CITY OF ALBUQUERQUE

**Re: FedEx Ground Interim Grading Plan
Engineer's Stamp Date 5-19-14 for sheet GR-2 and stamp date 6-11-14 for sheet
GR-4 (K09D026A)**

RONALD R. BOHANNON P.E. #7868	ENGINEER'S SEAL	FEDEX GROUND ALBUQUERQUE, NM	DRAWN BY DY
		GRADING AND DRAINAGE PLAN	DATE 7-22-14
			2013075-GRE
			SHEET # GR-2
			JOB # 2013075

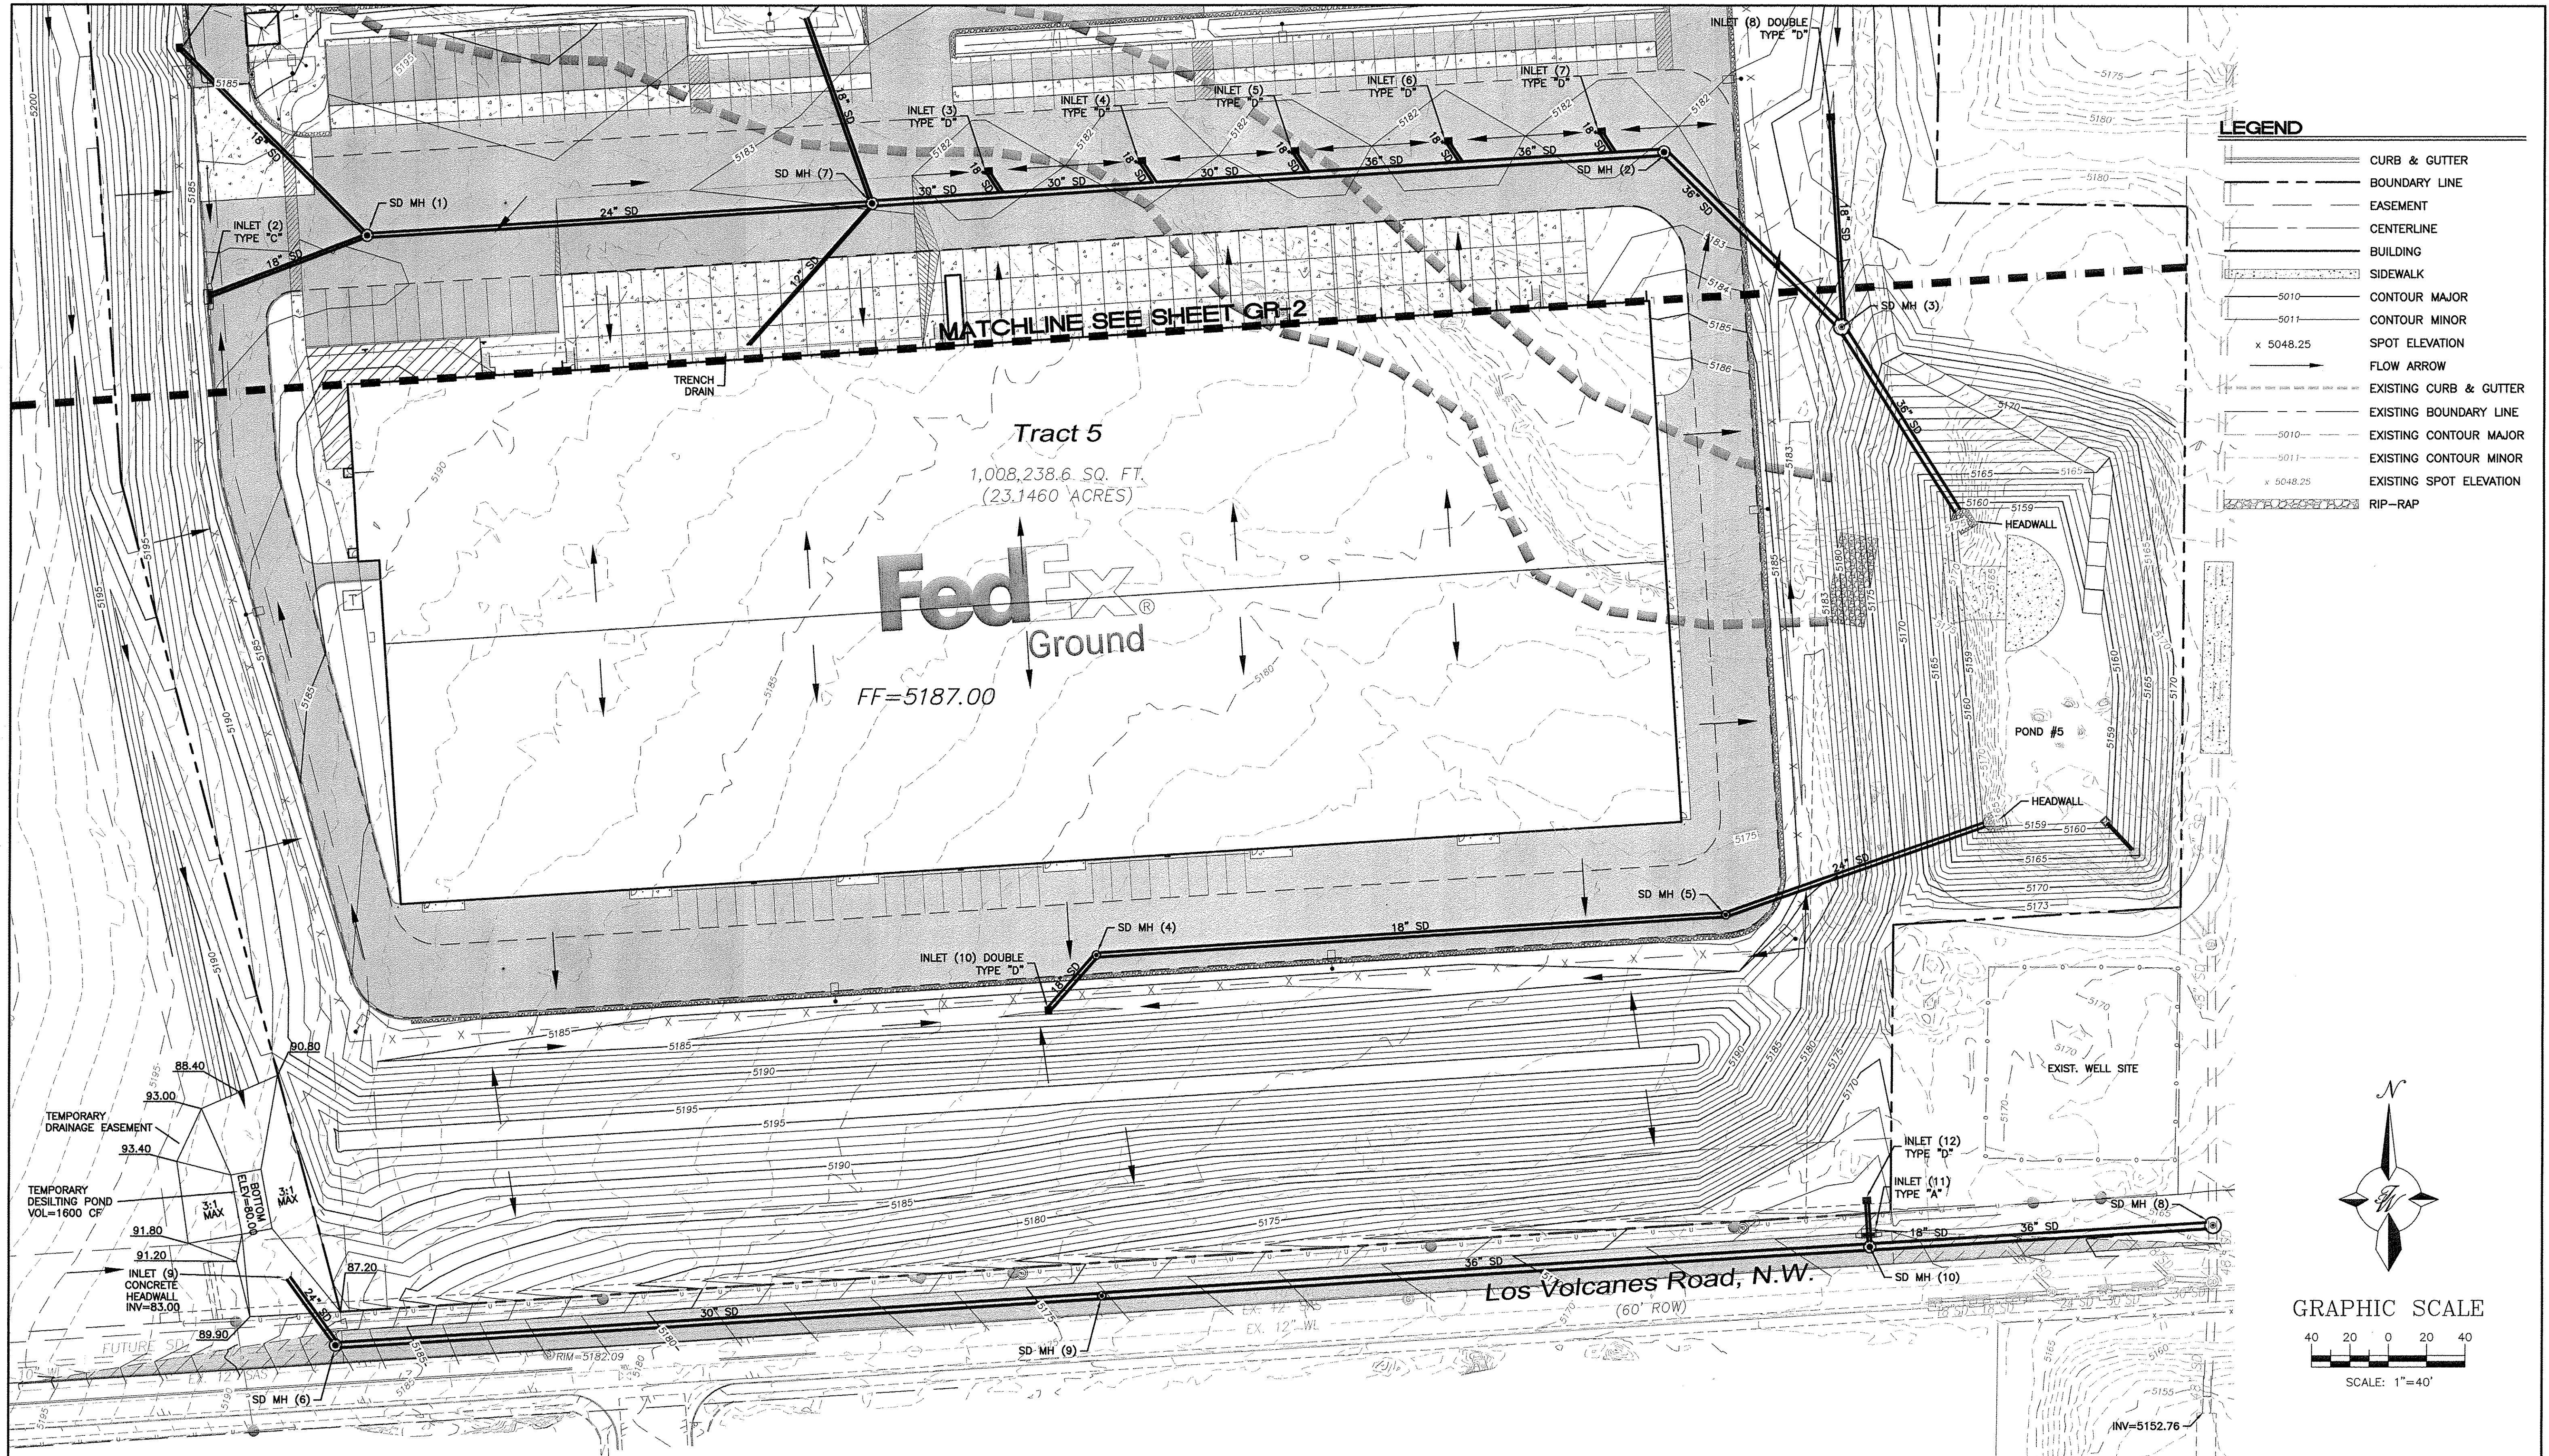
Hydrology is not approving pipe sizes, land treatments or finished grades as the drainage report has not been approved. In addition, since calculations to size the swale along Los Volcanos Rd was not provided it is the property owner's responsibility to ensure it functions properly.

ENGINEER'S SEAL RONALD R. BOHANNAN P.E. #7868	FEDEX GROUND ALBUQUERQUE, NM		DRAWN BY DY
	INTERIM GRADING AND DRAINAGE PLAN		DATE 7-22-14
	TIERRA WEST, LLC 5571 MIDWAY PARK PLACE NE ALBUQUERQUE, NM 87109 (505) 858-3100 www.tierrawestllc.com		2013075-GRE-INTERIM
	SHEET # GR-4		JOB # 2013075

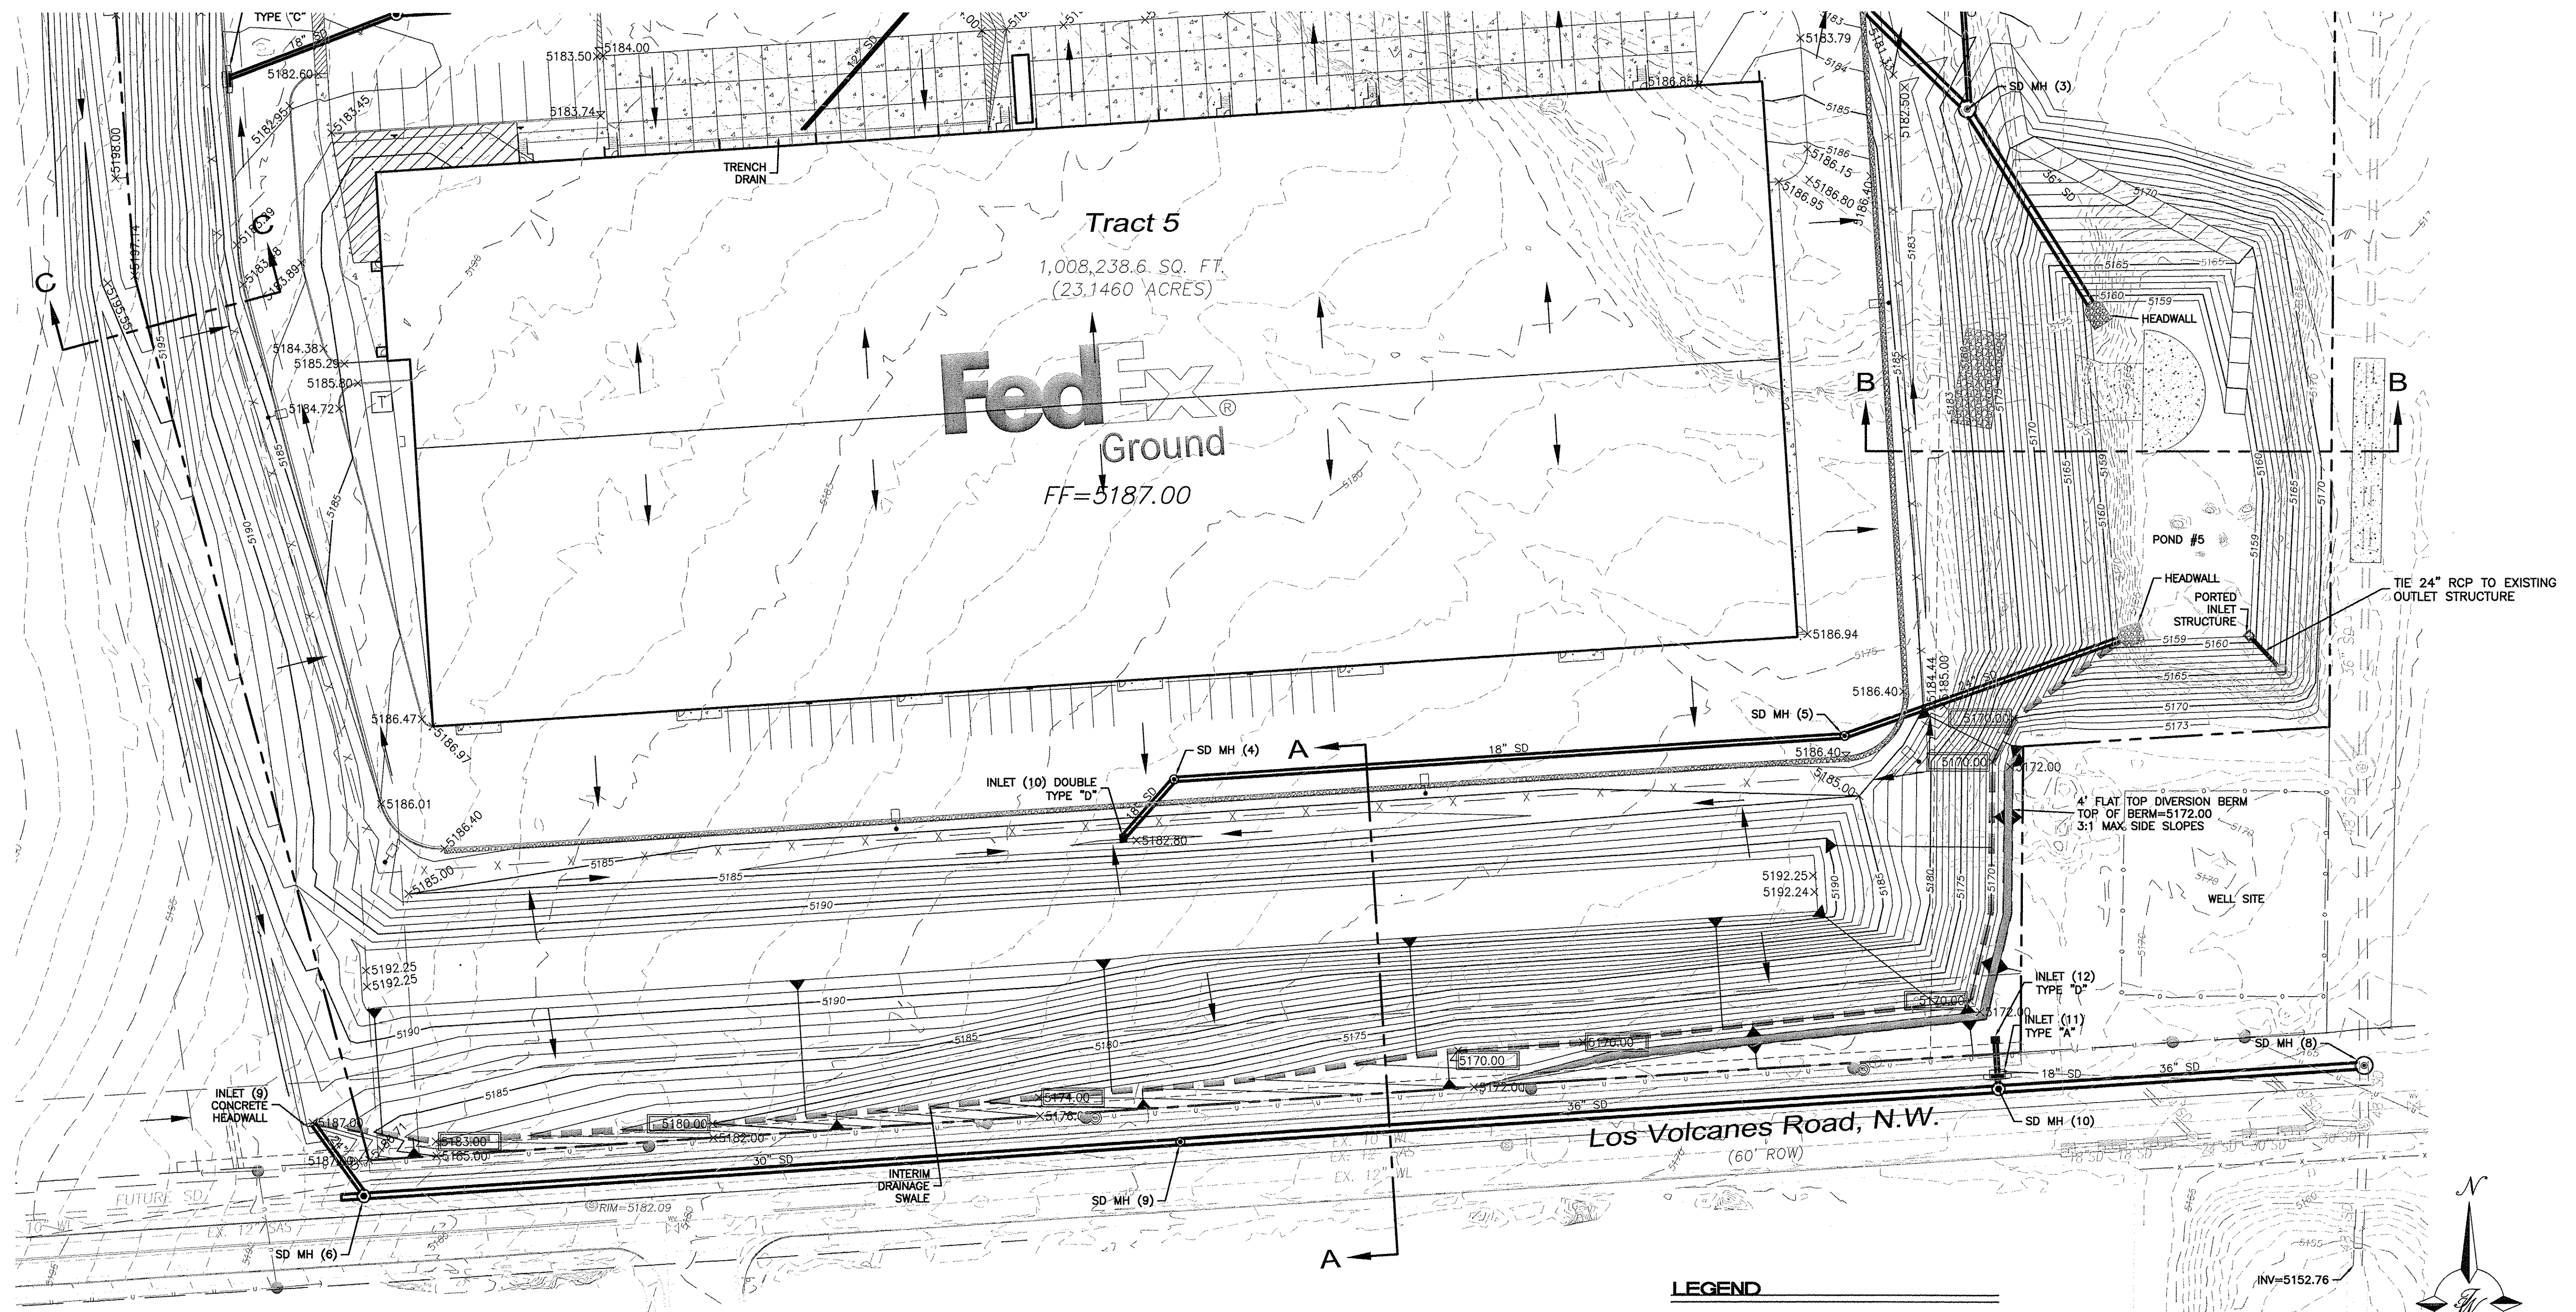
A slope easement is required on Tract 6 for Site Plan approval.
